**Sterling Recycling Facility
Transportation Memorandum
PCD File No.: PPR2241
(LSC #S224330)
August 24, 2023**

RE: Sterling Recycling Facility
Transportation Memorandum
El Paso County, Colorado
PCD FILE NO.: PPR2241
LSC #S224330

SITE DEVELOPMENT PLAN

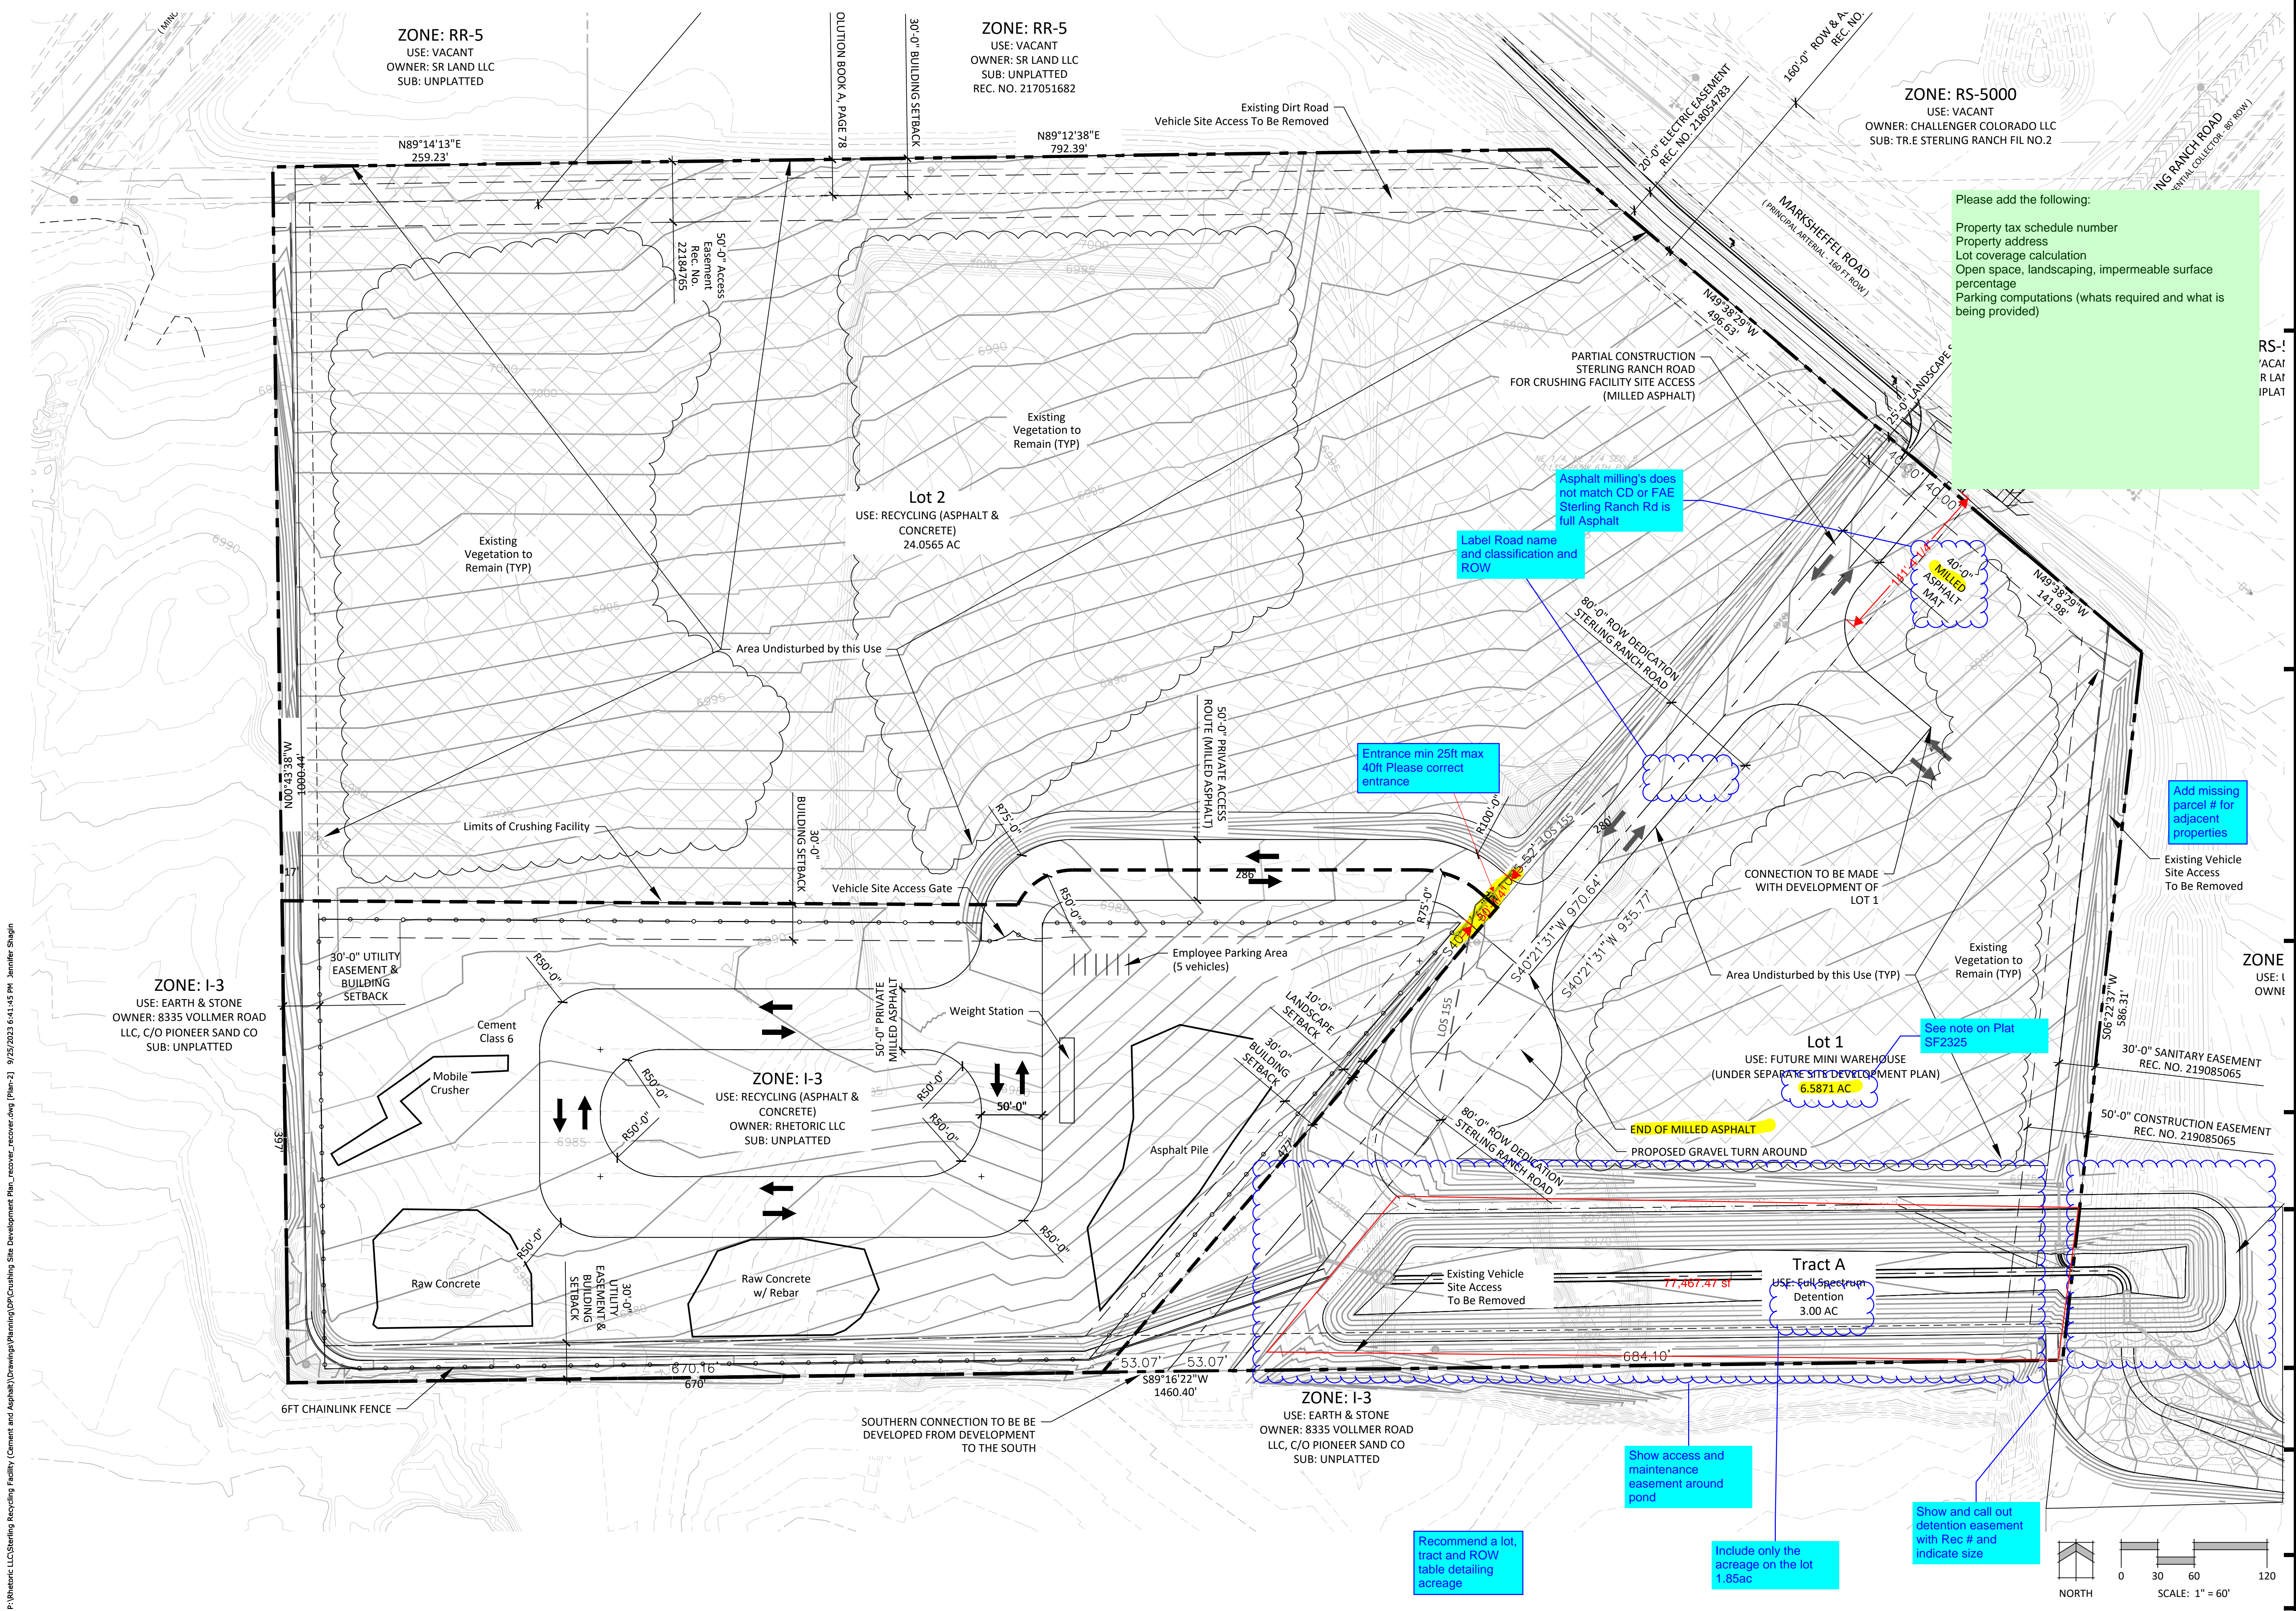
Please address access spacing for LOT #1 and proximity to Marksheffel along Sterling Ranch. Dependant on lot use type and traffic generation does this spacing meet requirement or should the access be moved further south close to the temp Cul-de-sac and a possible full movement with Lot #2. Spacing is only ~140ft and inside the transition lane area for EB and SB right turn onto Marksheffel. Left turns into LOT #1 do not seem to be addressed
